Online Comment

Application	H04-0268-20
Location	Land to the West of Malting Lane Donington Spalding
Proposal	Residential Development of 40 dwellings - outline approval H04-0244-16

Name	Black Sluice Internal Drainage Board
Address	Station Road Swineshead Boston PE20 3PW

Date Submitted	10-09-20
For/Against	Comments

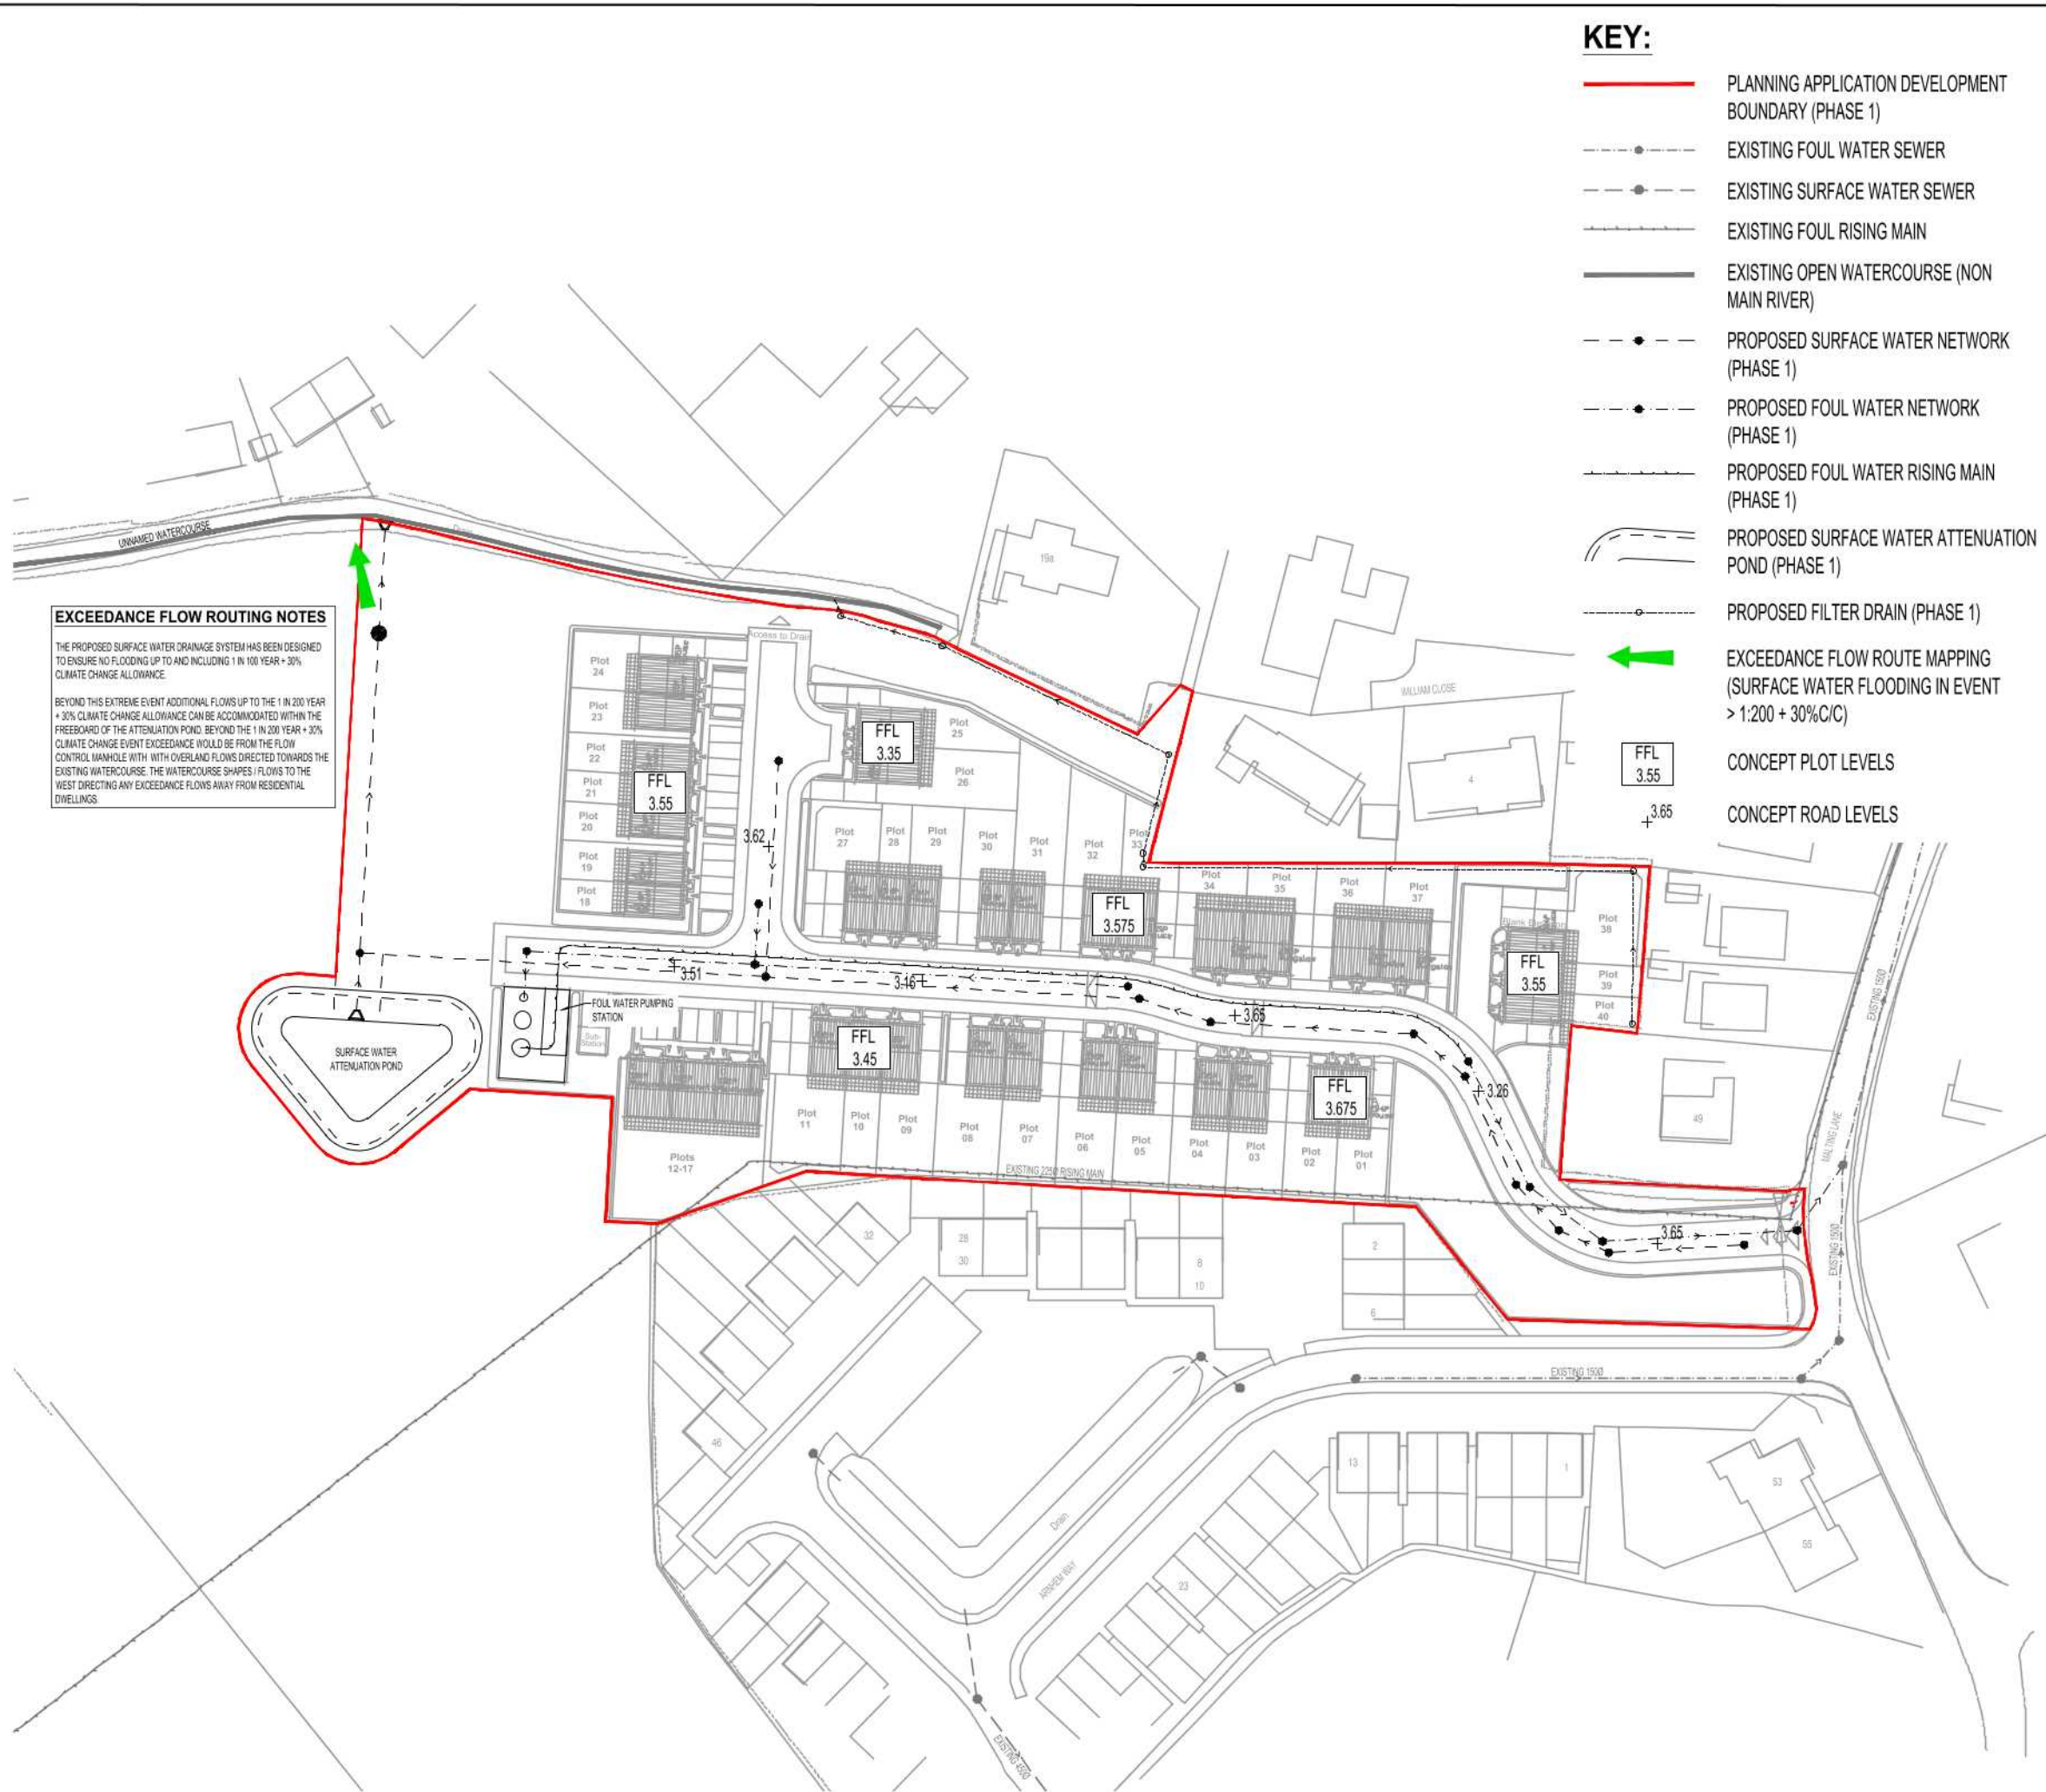
The Board has been in contact with the applicant's consultants, and the Board acknowledges the indication of a proposed filter drain along those boundaries. Whilst this acceptable to the Board in principle, the applicant will still have to prove to the planning authority that their proposals will work, and that should their proposals prove inadequate then they must accept responsibility for any future costs incurred by the adjacent property owners for any damage caused by future flooding.

The applicant is reminded that the Board cannot approve the overall site drainage scheme, and that prior written consent will be required for the proposed attenuated discharge from the developments drainage scheme, and for the new outfall from the proposed filter drain, both of which will discharge into the Board-maintained watercourse on the northern boundary.
